Appendix A – Response to Submissions Table

This Appendix provides a detailed summary of the Applicant's response to the issues raised in submissions to SSD-80211463.

Table 1 DPHI RTS Response

Figure 7: Pedestrian wind speed measurement locations with comfort/safety ratings – SSDA Scheme (Configuration C)

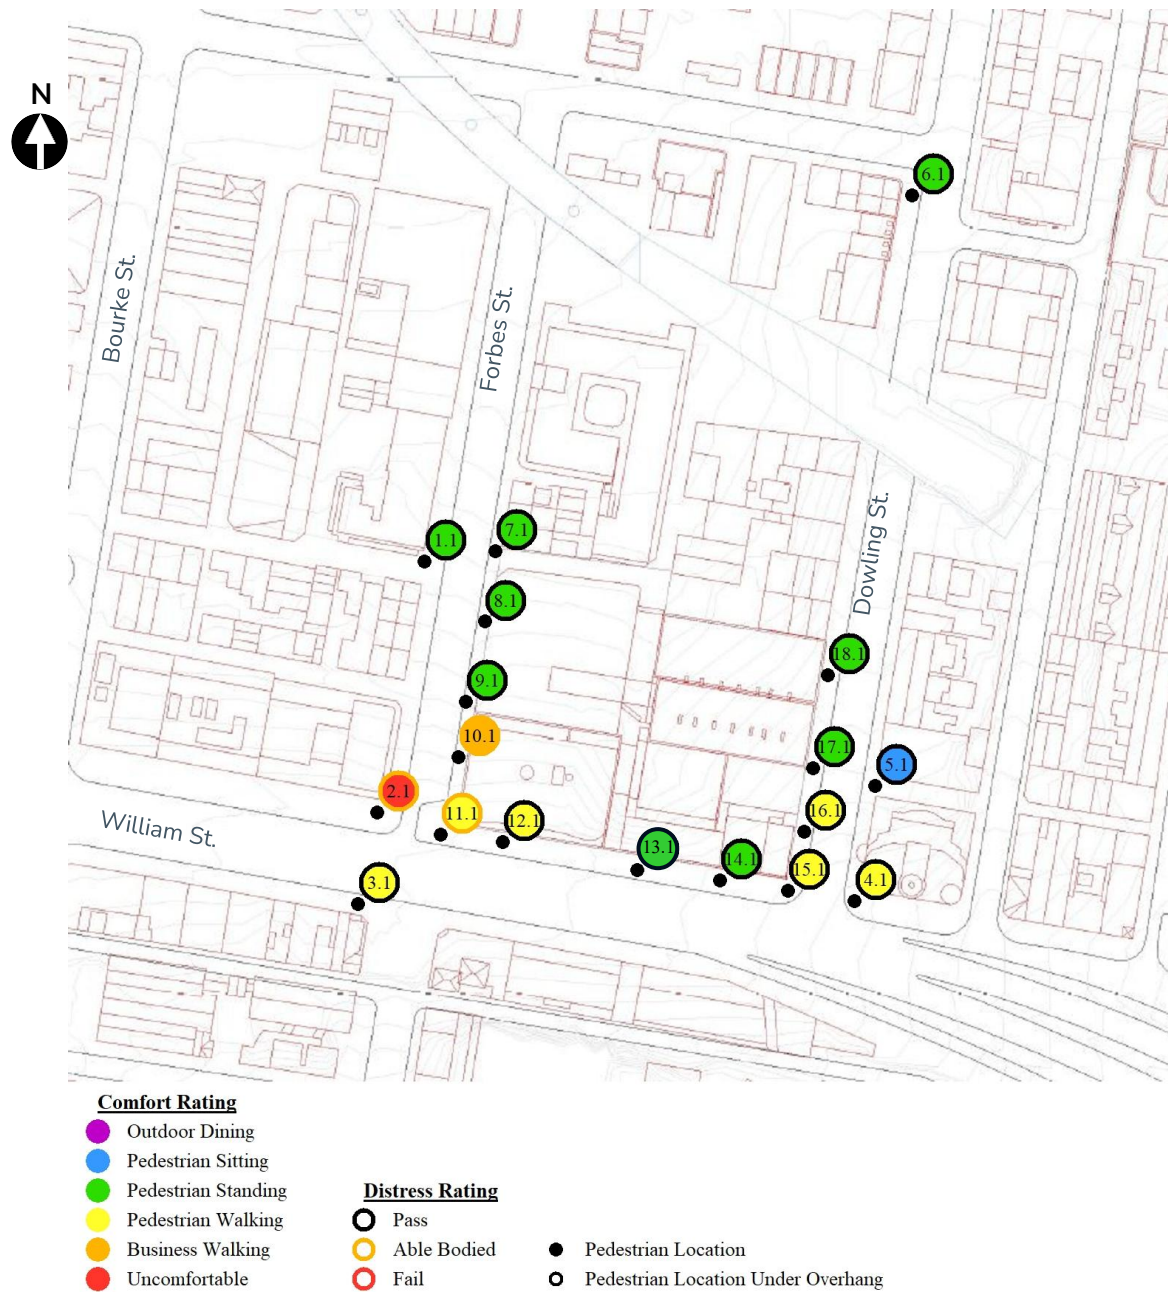
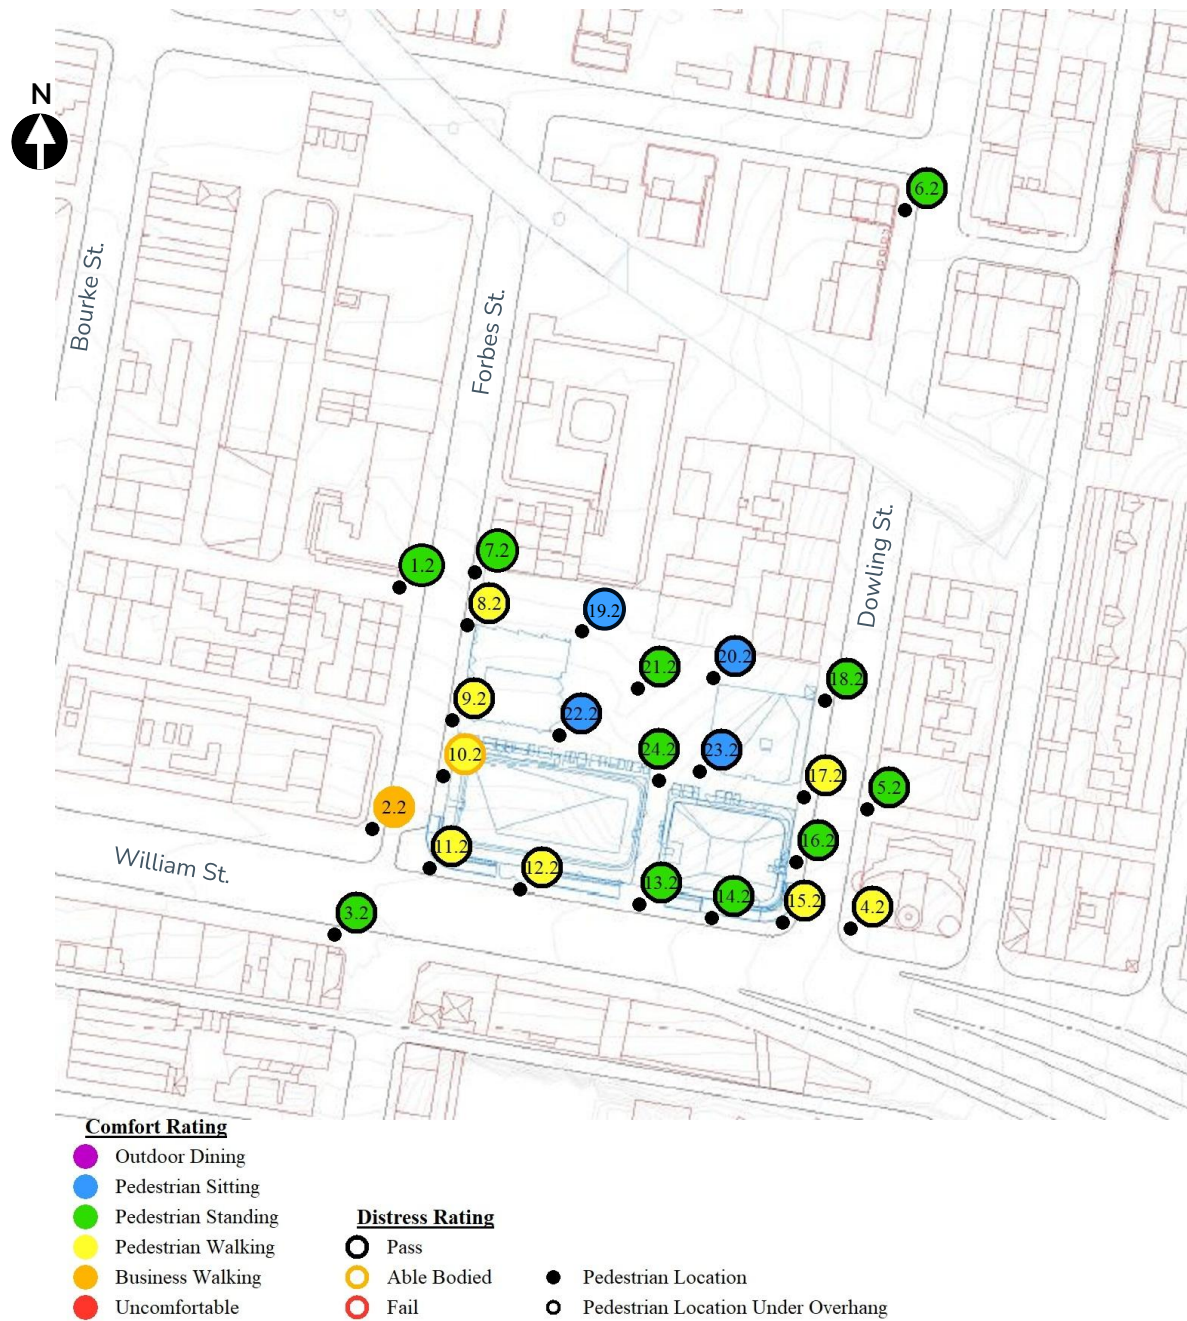
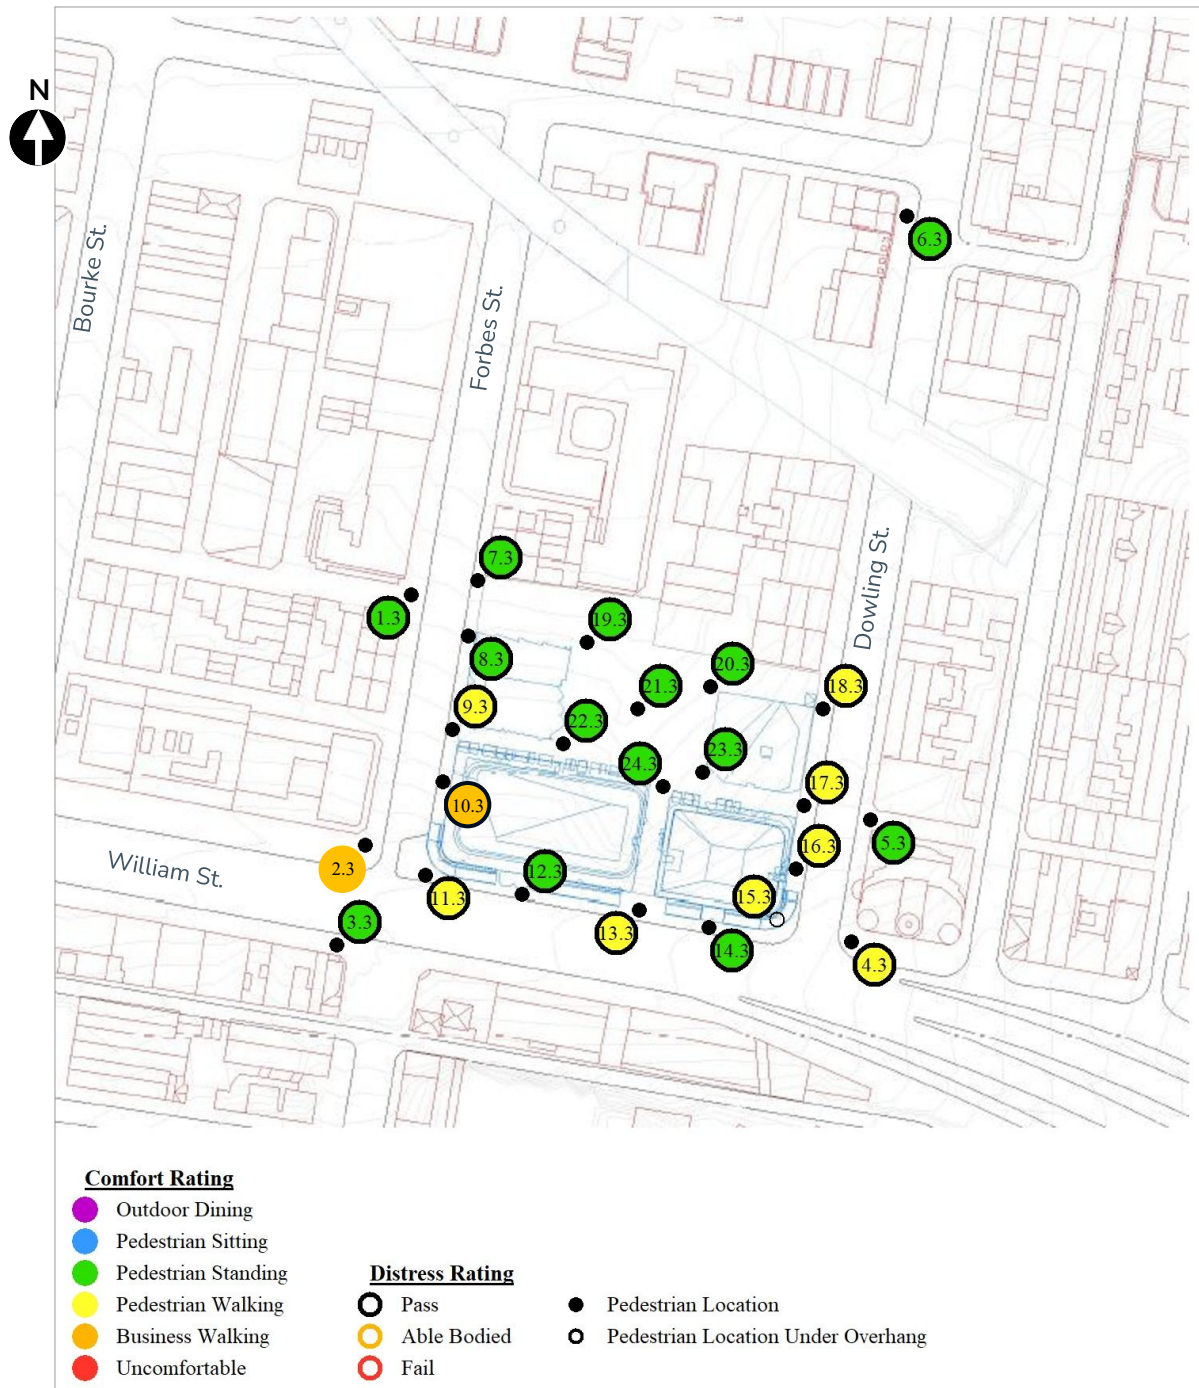
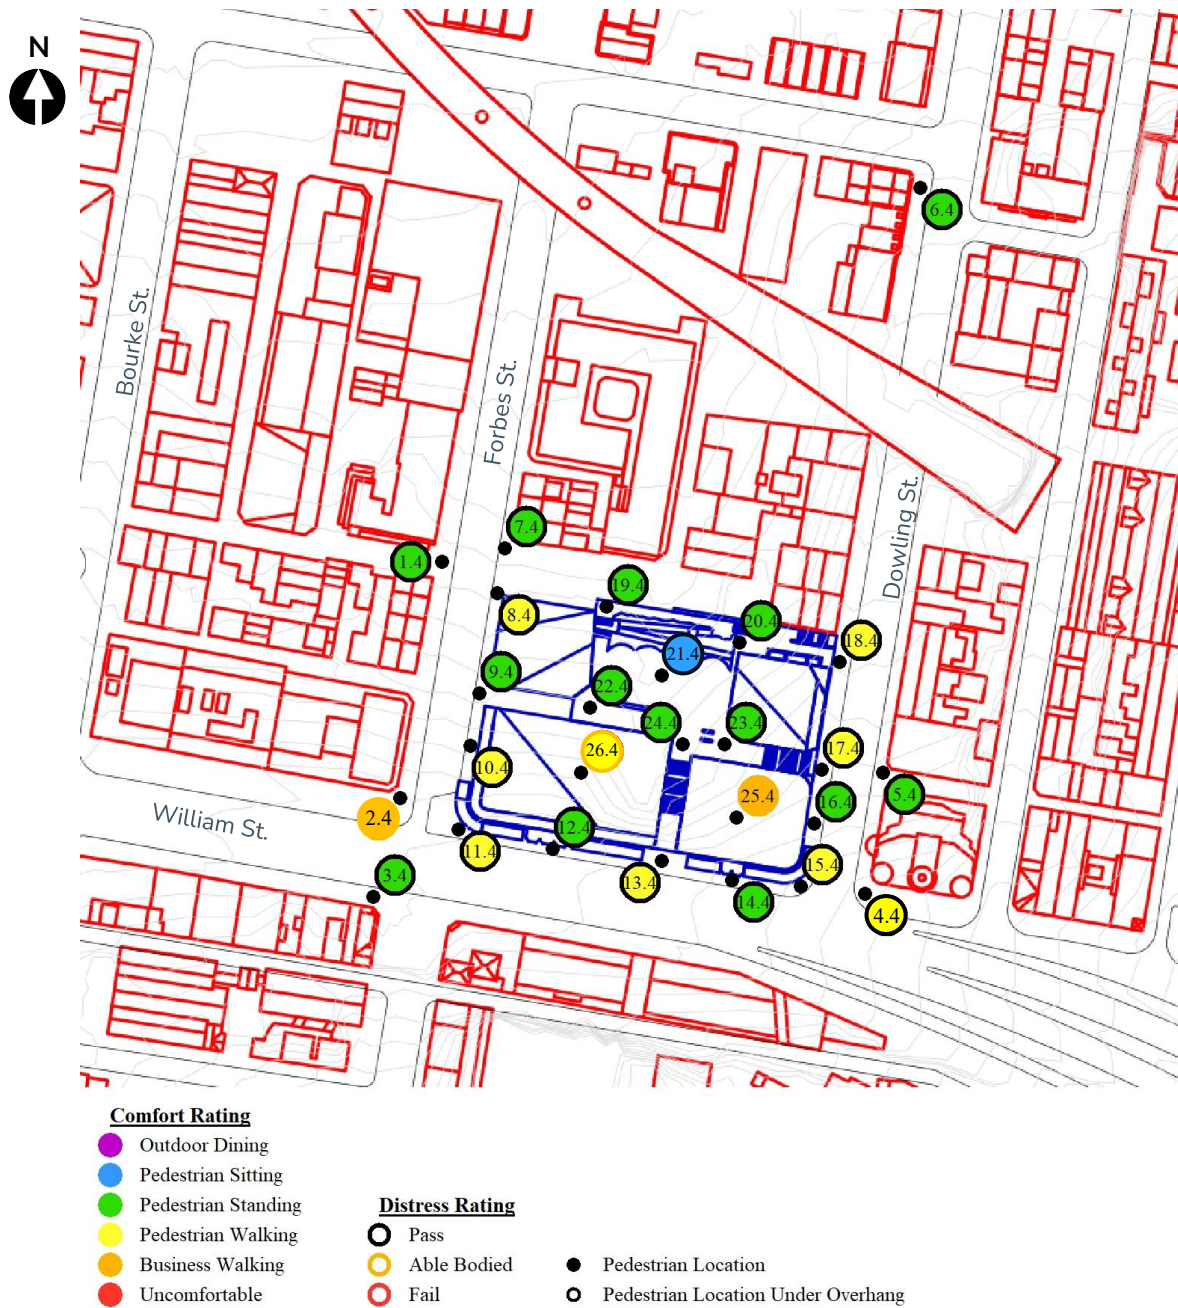
<p>47 b. The Central Plaza achieves a comfort rating of "Pedestrian standing" which is a reduction in comfort compared with the "Pedestrian sitting" rating of the earlier comparative scheme. The proposal must consider further mitigation measures to maintain comfort for sitting.</p>	<p>The measured wind conditions in the park without landscaping are similar to those experienced in Belmont Park and Wynyard Park. Additional mitigation measures have been incorporated including vertical screens between outdoor seating areas, and tree planting to the north of the plaza. These are expected to improve wind conditions in the Central Plaza space and are considered appropriate for achieving the desired outcome for this area. The combined wind conditions in the Central Plaza are demonstrated to be suitable for pedestrian sitting in the concept DA and blanket uplift schemes. With the addition of the proposed mitigation measures, Pedestrian Sitting is capable of being achieved in the central plaza area for the proposed SSSA design.</p>	<p>Refer to the Updated Pedestrian Wind Assessment at Appendix K.</p>

48	<p>c. Confirm "Configuration B' in the wind report is the approved concept envelope/development. Wind analysis should also compare against the blanket 30% uplift scheme to be consistent with the approach to analysis of other impact issues.</p>	<p>Confirming that 'Configuration B' is the approved concept envelope. The Wind Report has been updated to make this clearer.</p> <p>In general, the proposed SSDA development has a neutral impact on the measured wind conditions in and around the site when compared to the 30% blanket uplift scheme.</p> <p>Amendments have been made to the development since wind tunnel testing of the SSDA scheme in May 2025. From a wind perspective, the SSDA envelope as currently proposed is very similar to the tested configuration as lodged, with the building on the corner of William Street and Forbes Street being 1 storey taller, and the William Street East building being one storey lower.</p> <p>Wind conditions for the current SSDA envelope would be expected to be similar to those tested in the lodged scheme and retesting of this updated configuration is considered unnecessary.</p> <p>Additionally, wind mitigation measures have been incorporated within the central plaza to create localised calmer areas suitable for pedestrian sitting. With these measures in place, the SSDA scheme is expected to achieve wind conditions broadly equivalent to the lodged configuration.</p>	<p>Refer to the Updated Pedestrian Wind Assessment at Appendix K.</p>

Figure 10: General Arrangement Plan – Level 9 – William Street West Building

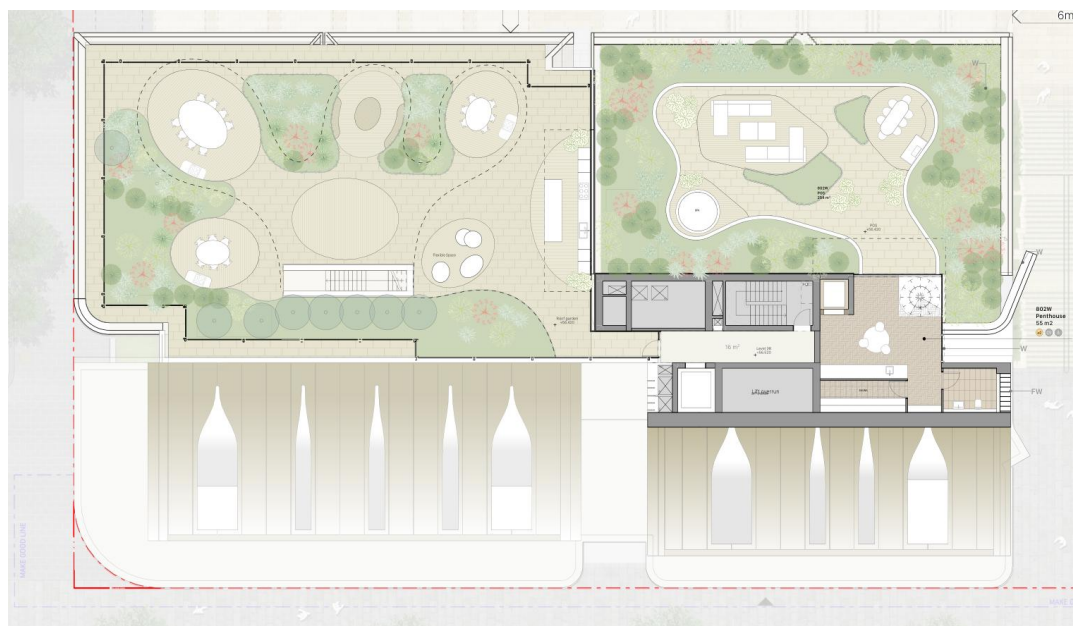
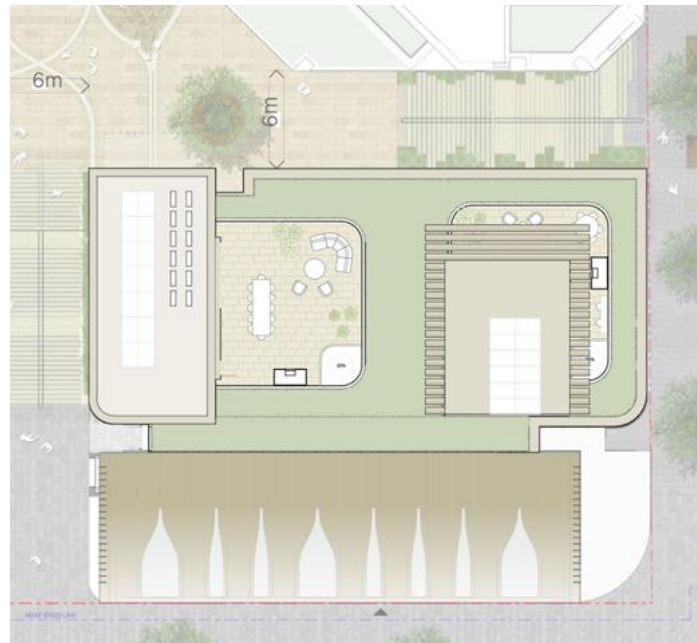
Wind			
46	a. Prepare an updated wind assessment that addresses the rooftop communal open space areas and private open spaces. Demonstrate the proposal will achieve acceptable safety and	An updated Wind Assessment has been prepared with rooftop testing conducted on a flat roof with the blanket 30% uplift scheme to determine	Refer to the Updated Pedestrian Wind

<p>comfort levels of these areas. Provide further plans/details and mitigation measures, as needed, to demonstrate that the wind conditions in these areas will provide comfortable conditions for the intended use of the spaces.</p>	<p>the baseline results for use in predicting the conditions in the final configuration.</p> <p>The proposed roof layout includes a perimeter balustrade, landscaped zones and semi-enclosed areas. In addition, roof articulation to the south and the plant/lift overrun would provide shielding from certain wind directions, increasing the proportion of time that the rooftop open spaces are suitable for resident use.</p> <p>The proposed balustrade height has been increased in areas to a minimum of 1.8m to provide meaningful benefit to the wind conditions on the rooftop.</p> <p>The expected wind comfort on the rooftop areas of the proposed design is anticipated to range from Pedestrian Sitting in the semi enclosed spaces and more sheltered southern areas, to Pedestrian Walking near the northern edges. These conditions are typical for rooftop environments and is considered appropriate for the proposed development. Calm areas, suitable for sitting, are expected to be available for most wind directions.</p>	<p>Assessment at Appendix K.</p>
